Planning Application Reference No.: 3/2025/0997

Address of Development: Land Off Henthorn Road, Clitheroe, BB7 3BY

Comments: I wish to object to the above outline planning application.

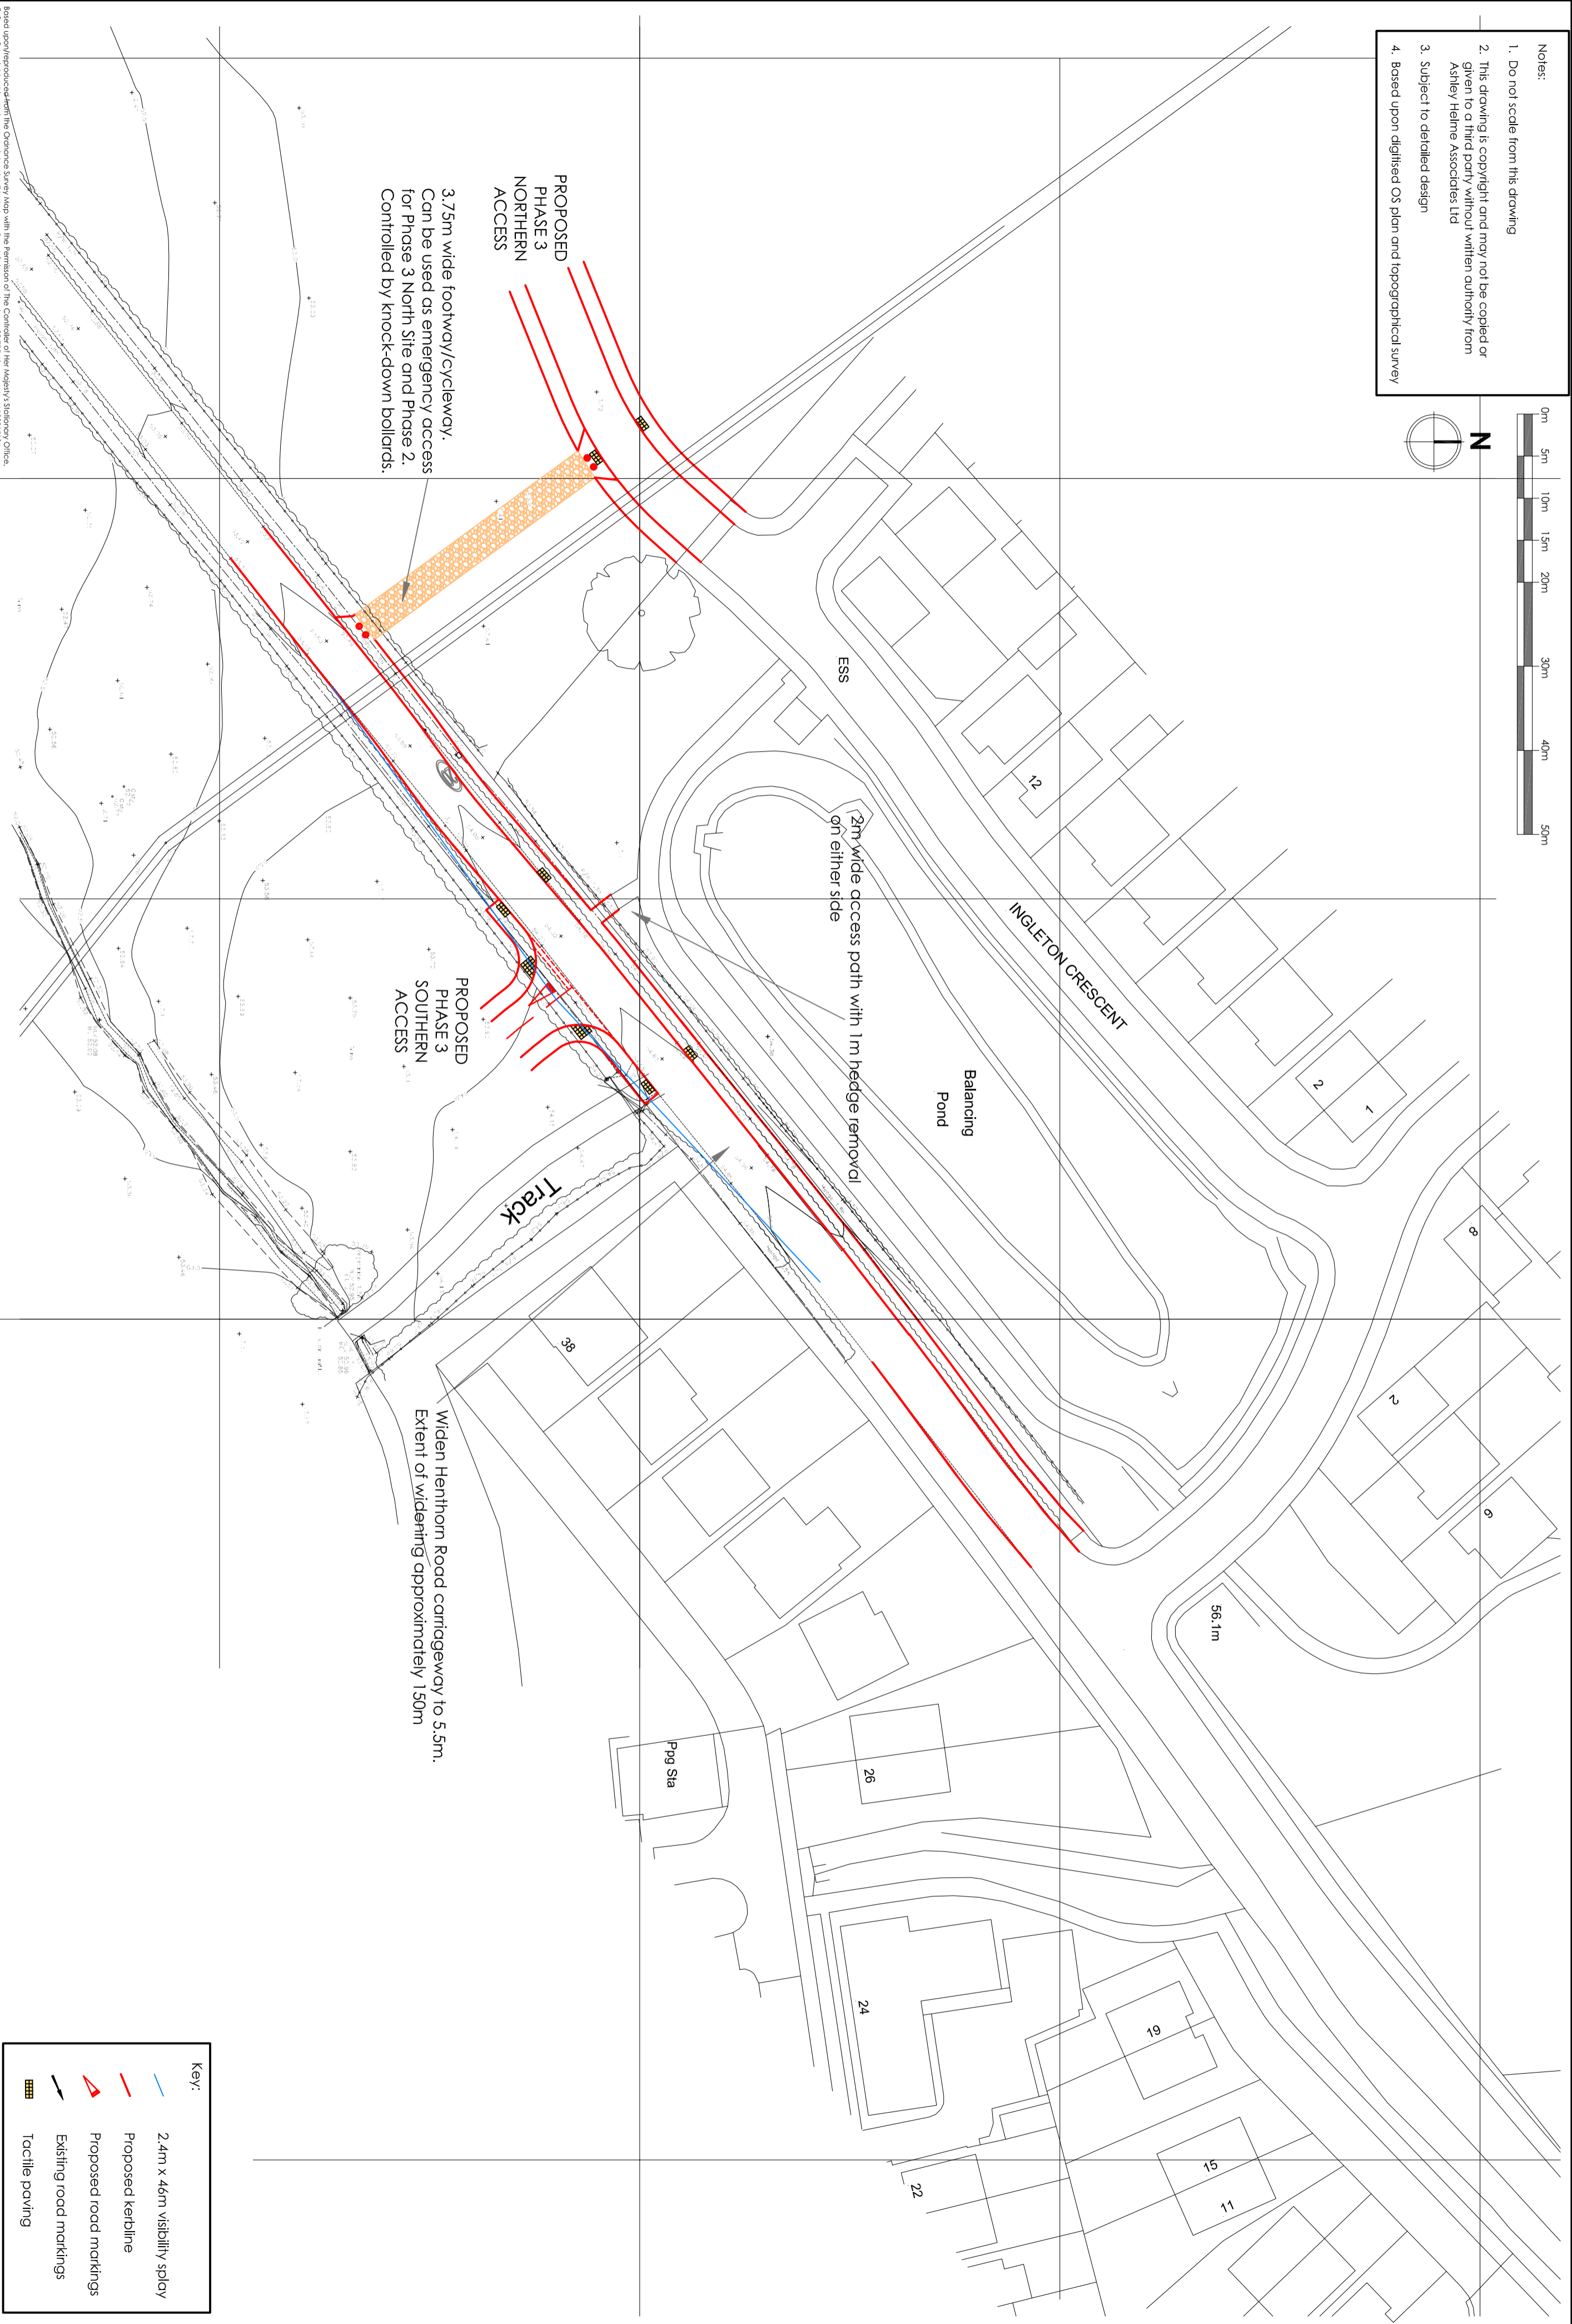
It makes no sense to have the access road via Ingleton Crescent, this road is not designed to take all the heavy duty traffic that would be required for the development of the site. IF the site was to go ahead the access should be via Henthorn Road like the other sites that have been added to the Road. Henthorn Road is not fit for purpose and is already severely congested, adding another potential 200+ cars to this will make access and exit very difficult and most importantly, dangerous as families regularly use Henthorn Road.

Comments: I object to this planning proposal in its current form based mainly on the access plan.

Access to the northern part of the proposed development is planned via Ingleton Crescent. This is part of the existing Miller Homes development which already has 110 properties and associated vehicles using it daily. Adding traffic from the additional 35 proposed homes on this side of the development will lead to increased congestion at the junction of Waterfall Gardens with Henthorn Road as well as increased noise and pollution.

In addition, the junction of Waterfall Gardens into Henthorn Road has severely restricted visibility due to the constantly overgrown hedges in both directions.

Moving the proposed entrance for the northern aspect of the proposed development further along Henthorn Road would more evenly distribute vehicular access / egress to Henthorn Road. This could easily be accommodated since the access statement also proposes widening of Henthorn Road to 5.5m as far as the proposed entrance to the southern side of the development.

Visibility of traffic leaving the wastewater treatment and household waste recycling centres at the far end of Henthorn Road is also clearer from further down Henthorn Road so I suggest that this would be a safer location for all road users.
